Comments on the Applicant's D1 Submissions

This document sets out the comments by Cambridgeshire County Council (**CCC**) on the Applicant's Deadline 1 (**D1**) submissions. The table below provides the relevant paragraph or other references used in the submissions.

Figure 2-5 Indicative Construction Access and Compounds (Rev P01)

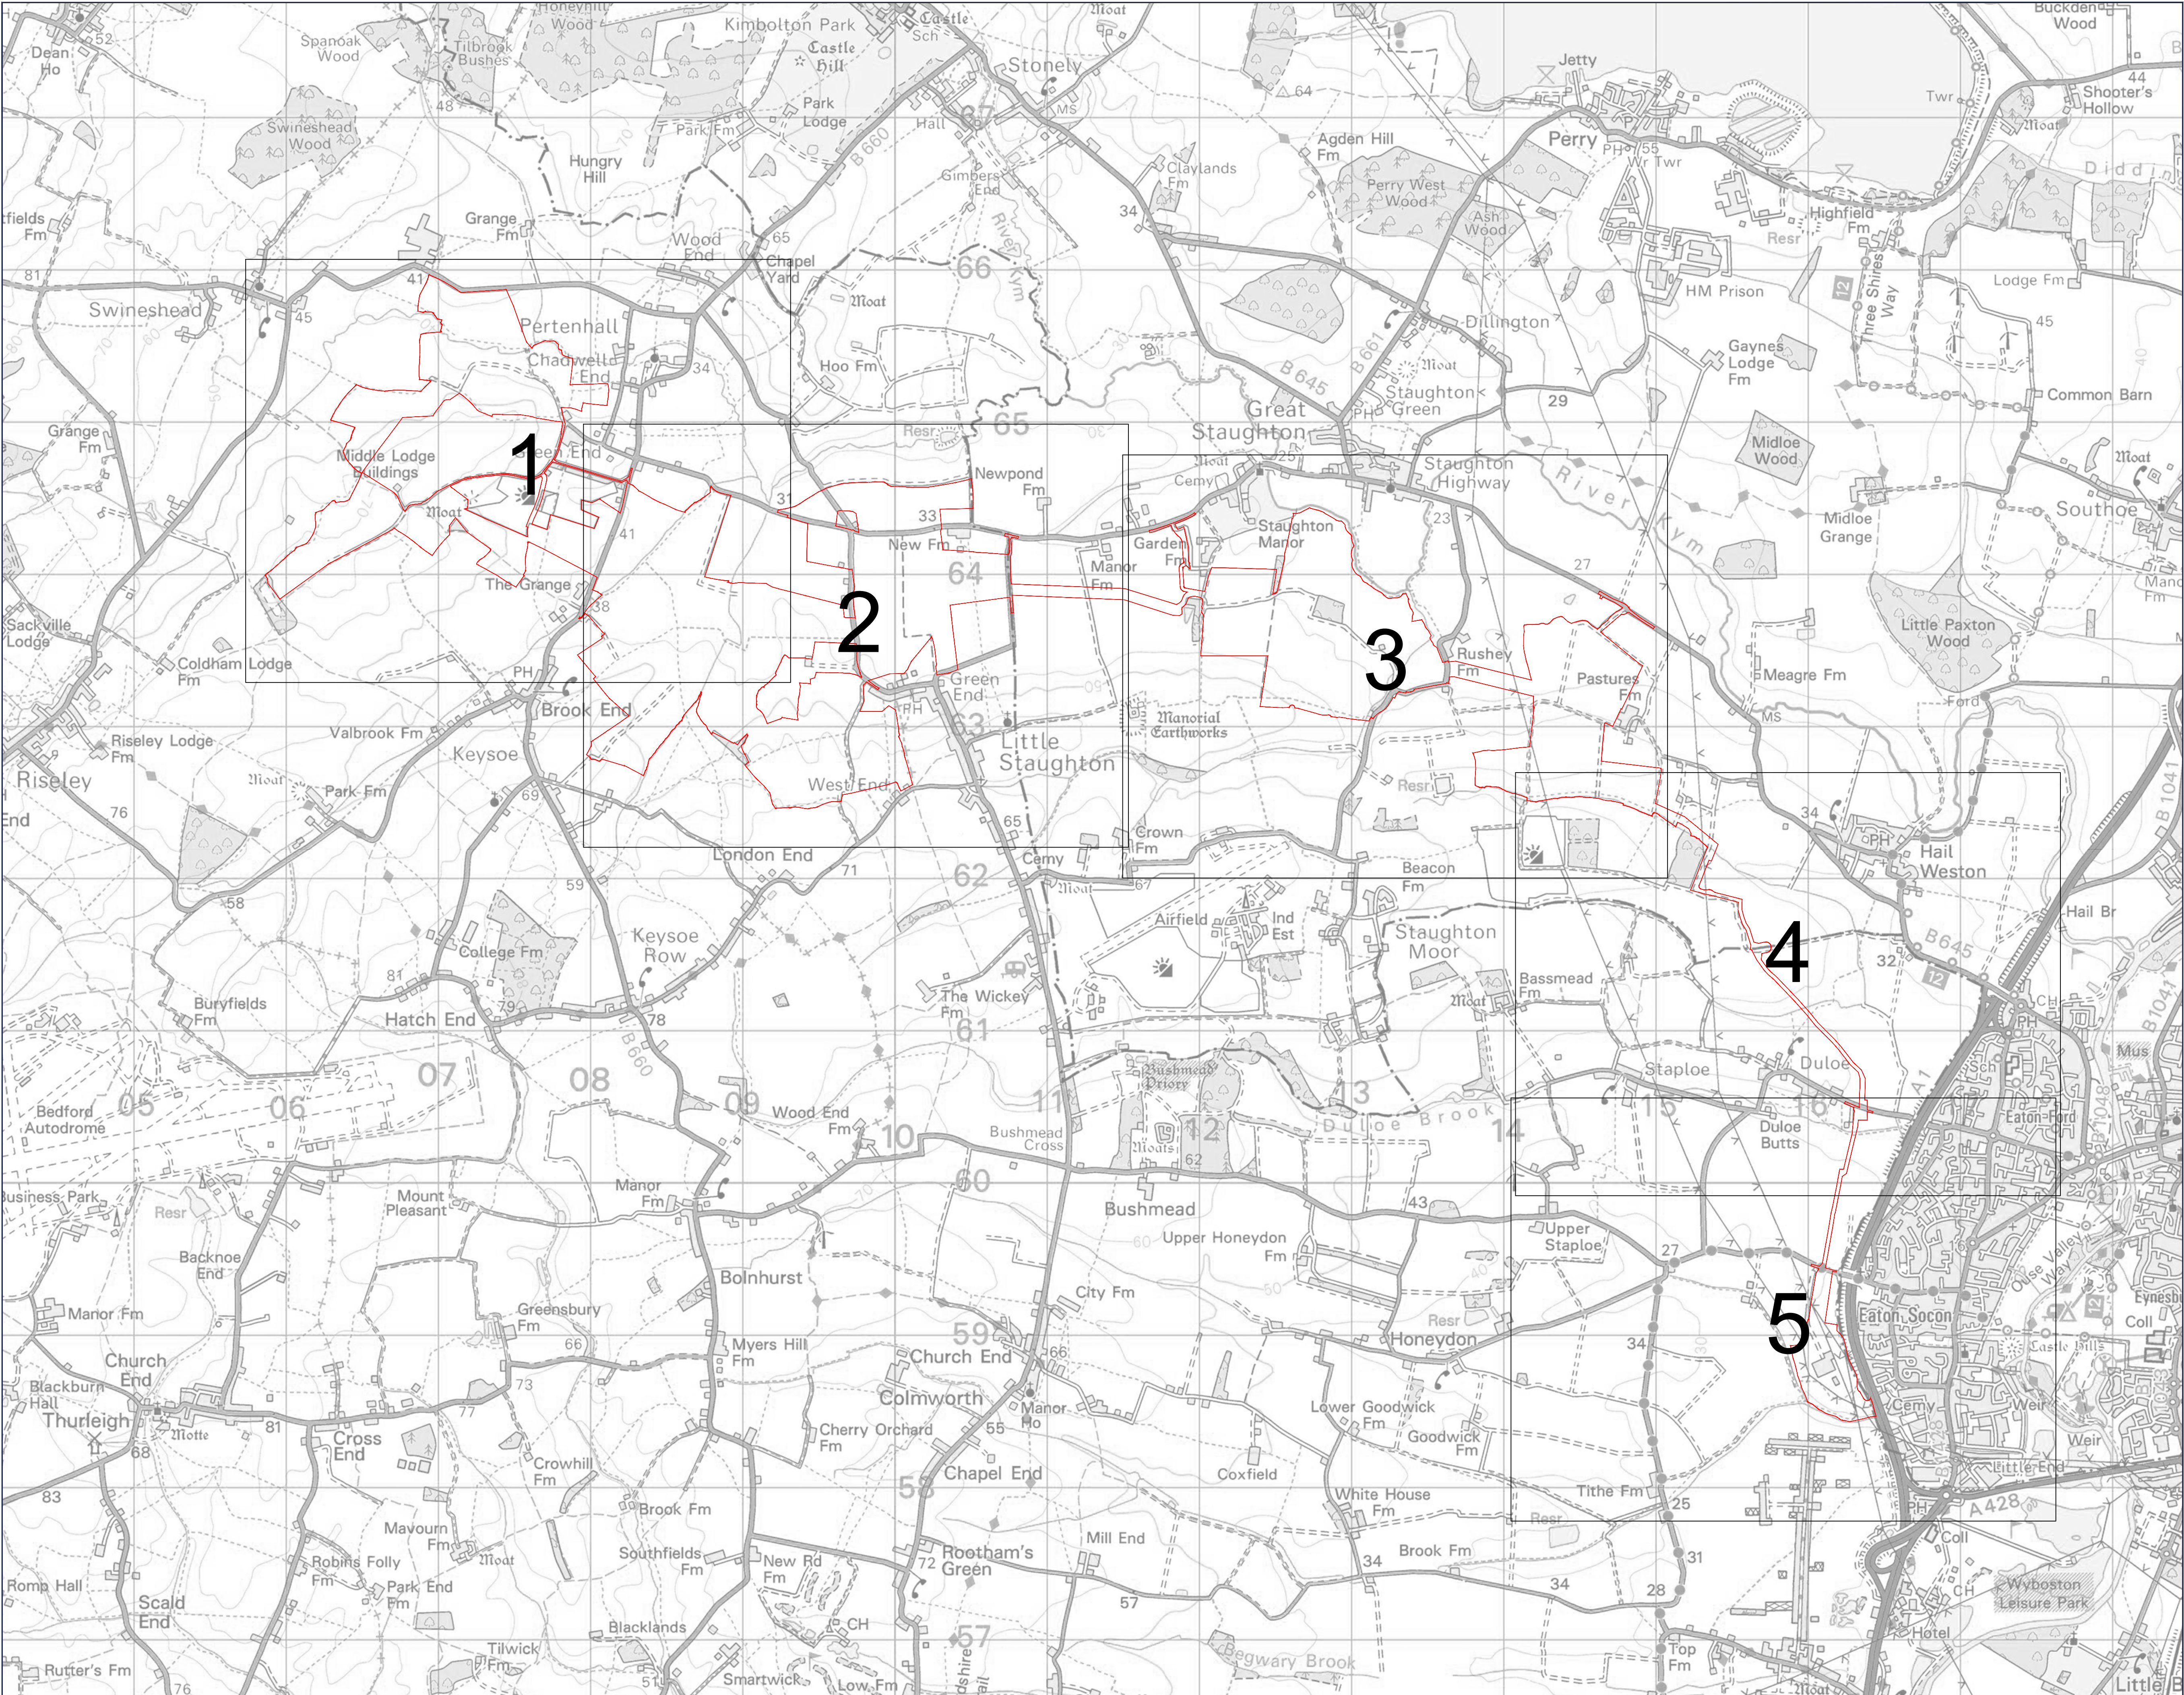
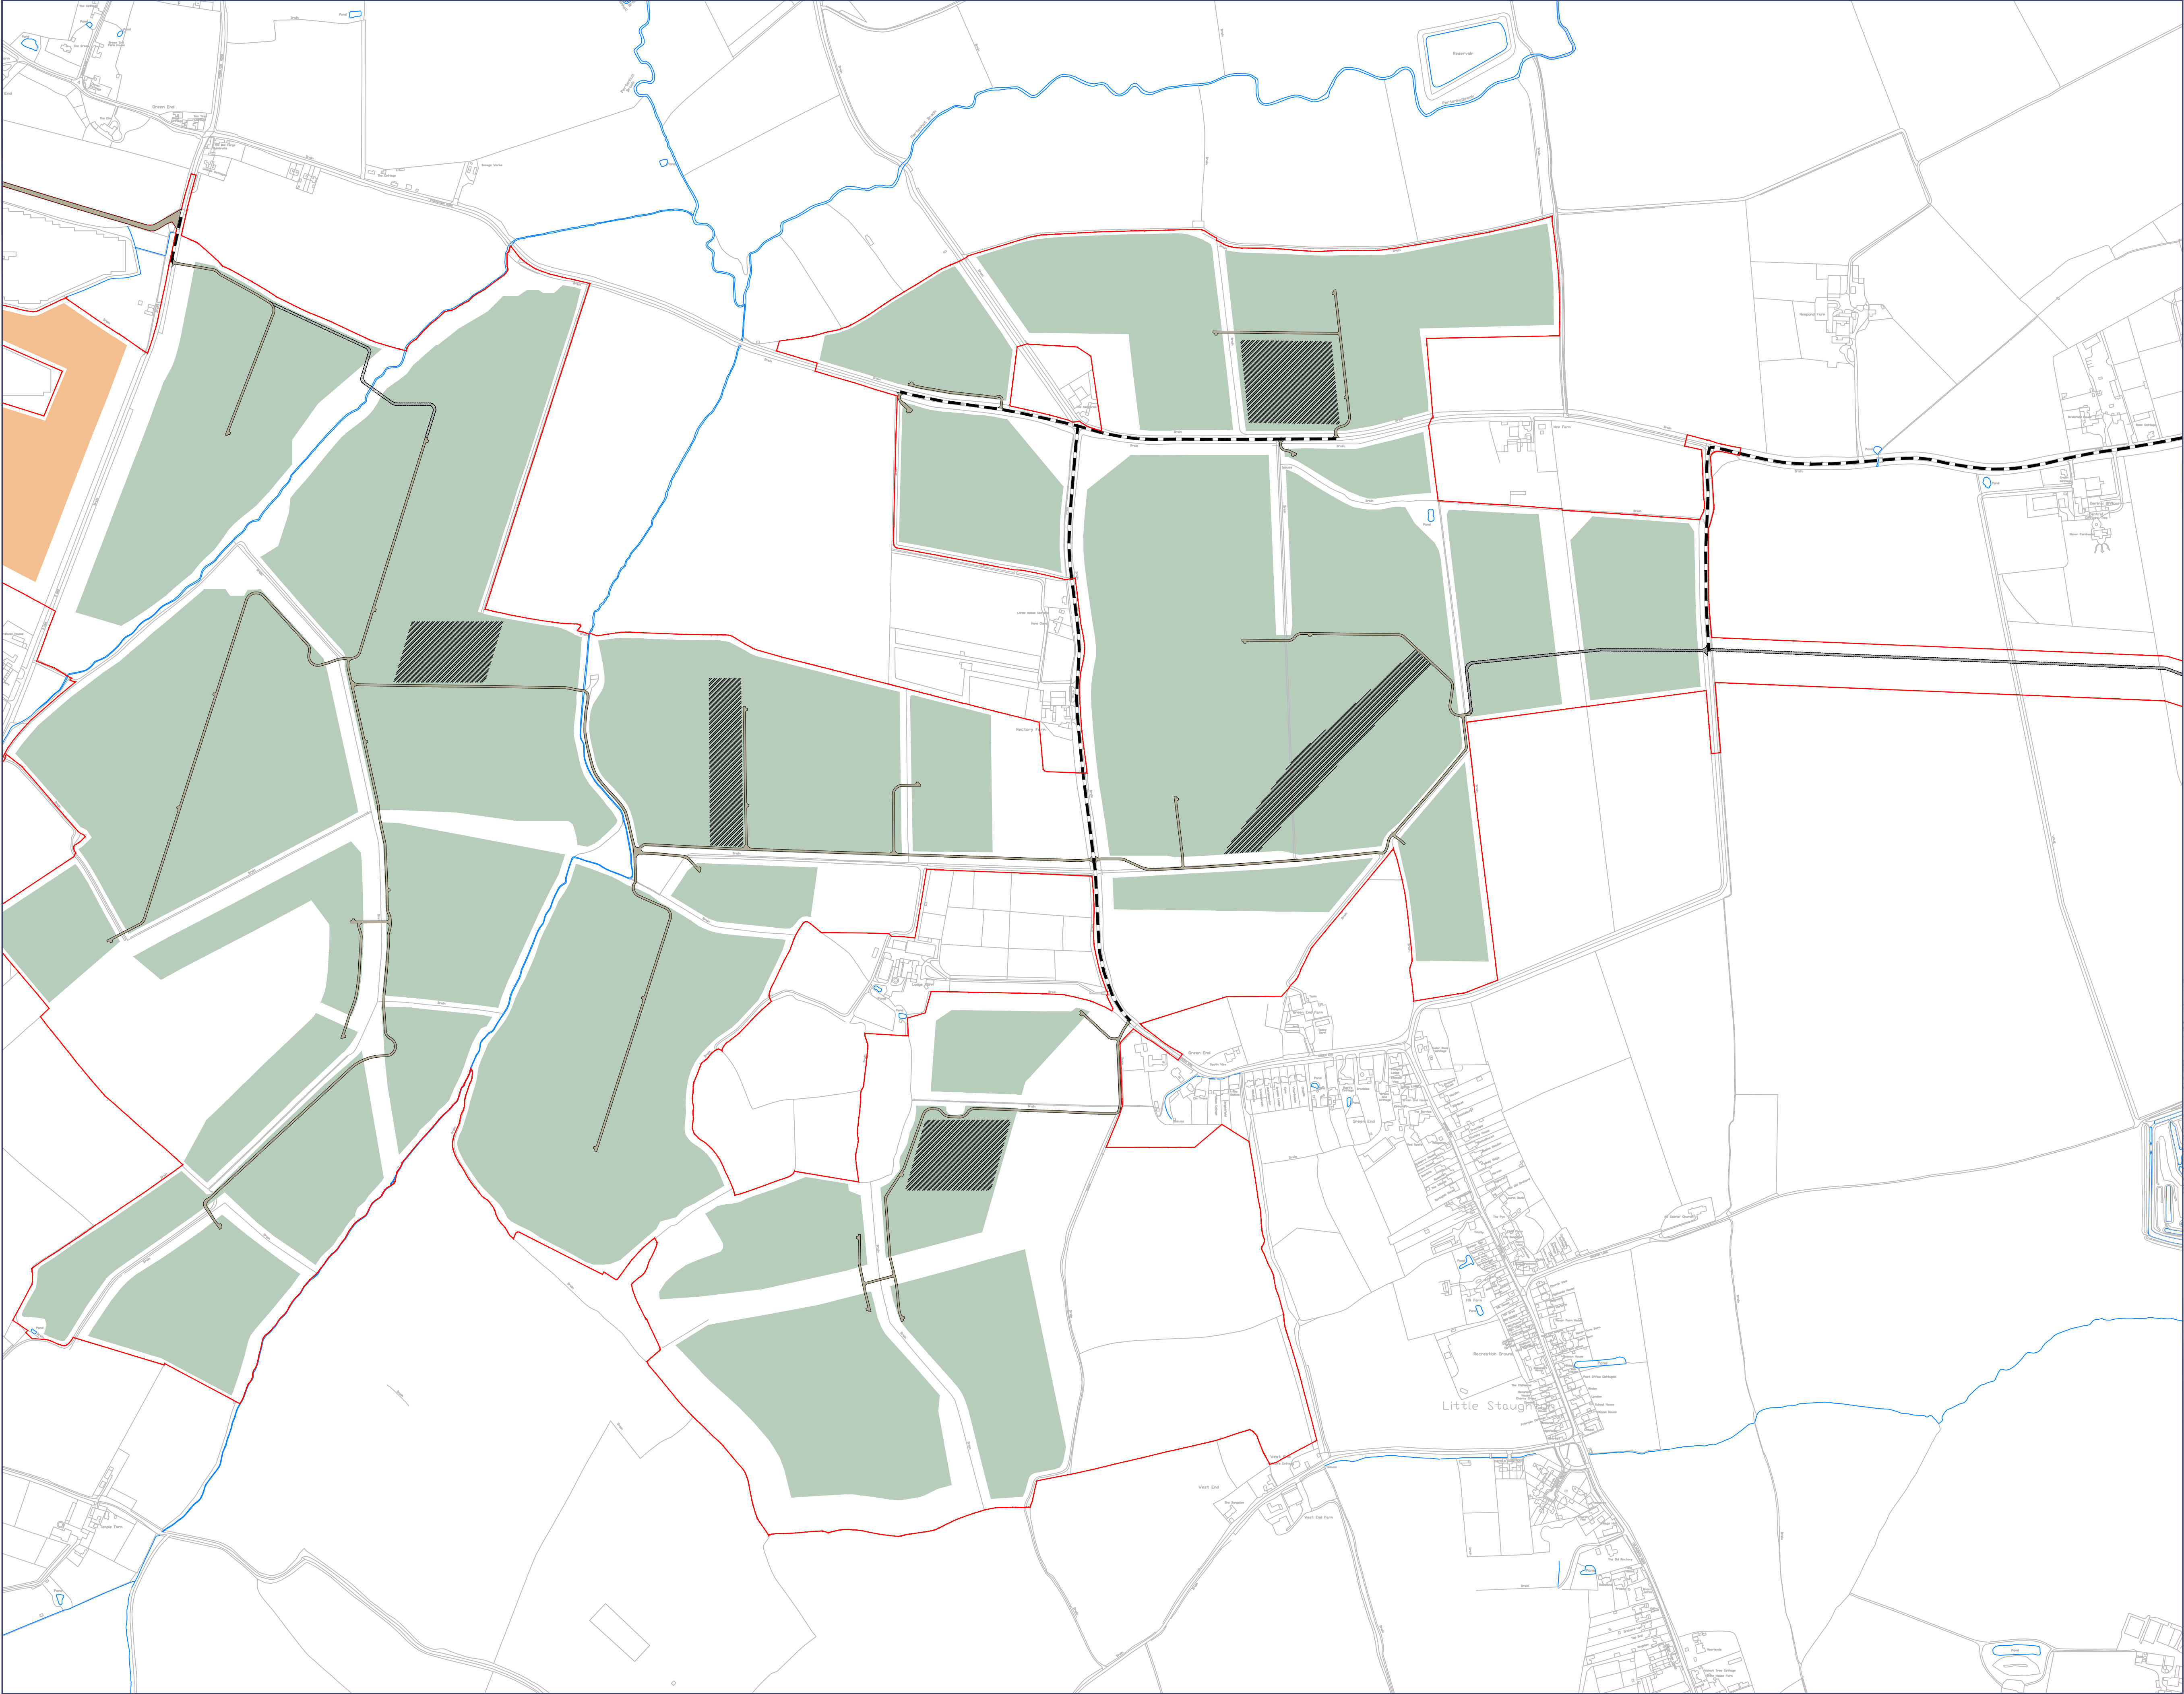
7.1.1	Each access should have a non-granular surface for a reasonable distance from the road edge where, if required, cleaning stations may be located.
Access drawing comments.	SA14 and SA15 Construction only accesses / crossing point	Visibility requirement has not been met as indicated before, the recorded speeds are above those required to assess by Manual for Streets requirements i.e. above 37mph. It is noted, however, that the speed surveys were carried out remote from the location of this crossing. Therefore, either further speed surveys will be required, or temporary traffic regulation orders would be required to reduce the speeds of vehicles with appropriate warning signage.

With regards to the access width, it is noted that two vehicles are unable to pass at the location of the crossing with a 4m width. The crossing should be of sufficient width to allow two-way simultaneous movements at locations adjacent to the highway. While it is indicated within the CTMP that vehicles will be controlled so that none should meet, this safeguard should be built in as standard to mitigate for such instances.

A width of 7.3m for a distance of 20m from the road edge should be sufficient.

<p>The council queries why 4m radii have been applied to the design. As no vehicles are proposed to use Moore Road, the inclusion of these would only seem to allow manoeuvres. The council requests that the applicant removes these to ensure straight across movements only. Moore Road has limited width to accommodate construction traffic for the project.</p>
	<p>SA13 operational access</p>	<p>Whilst this is an existing access, the council has not seen any information relating to the existing use and or proposed use, so requests clarity on whether there will be additional volume.</p> <p>The proposed splays are also indicated but no speed measurements have been undertaken in this location to ascertain if they are adequate.</p> <p>The tracking has been undertaken with a 10m rigid vehicle – the council requests clarity as to whether this is the largest vehicle likely to use the access, with details provided of the frequency to ensure the single width nature is acceptable.</p> <p>The council also notes that it is not a balanced junction regarding radii, and requests further information as to whether any vehicles using the access will only enter and leave from the North.</p>

<p>SA16 Main construction access</p>	<p>In the tracking plan provided, the vehicles appear to clash when manoeuvring in the location below. The council requests that the applicant provides tracking or alters the geometry so that this does not occur.</p> 
	<p>SA12 Zantra access</p>	<p>The council notes that this access has already got approval for HGV use and there is no damage evident on Google Earth.</p>
